V_2 GEC.pdf Markup Summary

Subject: Callout
Page Label: [26] 26 POND E - OUTLET STRUCTURE DETAILS
Author: CDurham
Date: 4/11/2024 5:36:52 PM
Status:
Color: ■
Layer:
Space:

POND E - OUTLET
 STRUCTURE DETAILS

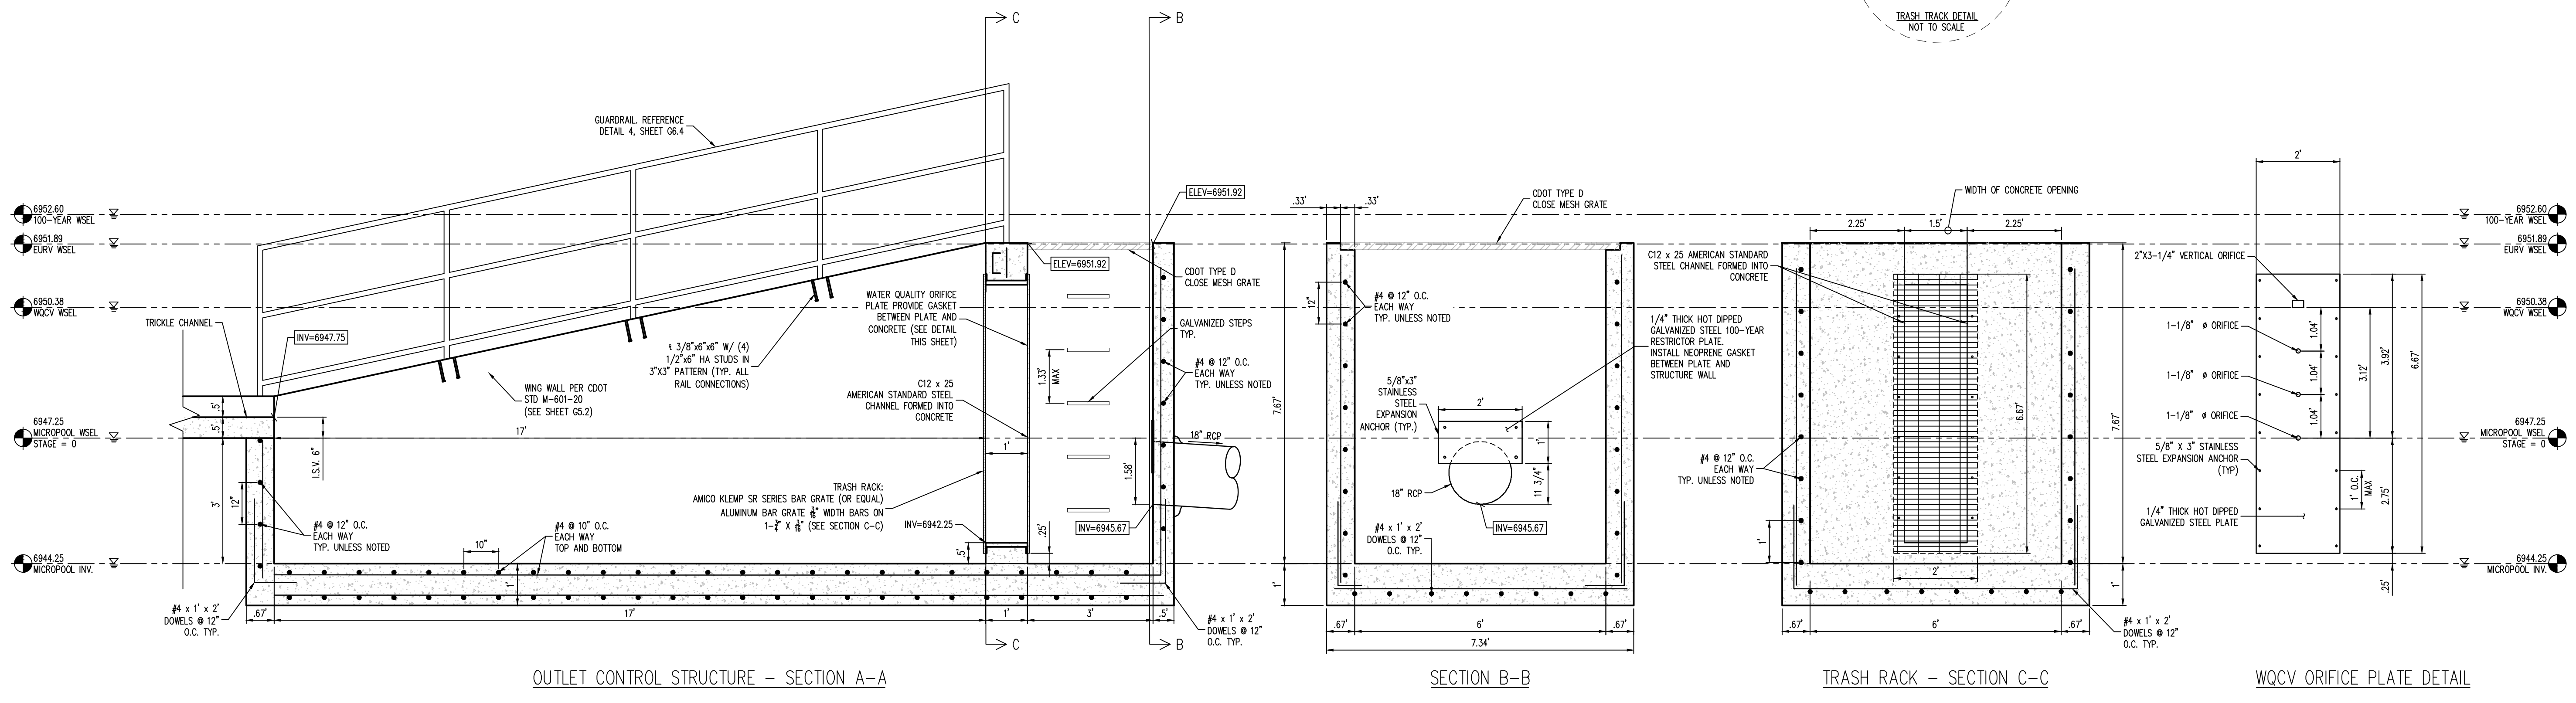
Label end section or headwalls, riprap apron (length, depth, type, D50), toe wall if needed, profile of existing ground shown for 200 feet downstream of outfall, Q100 water surface elevation downstream of outfall
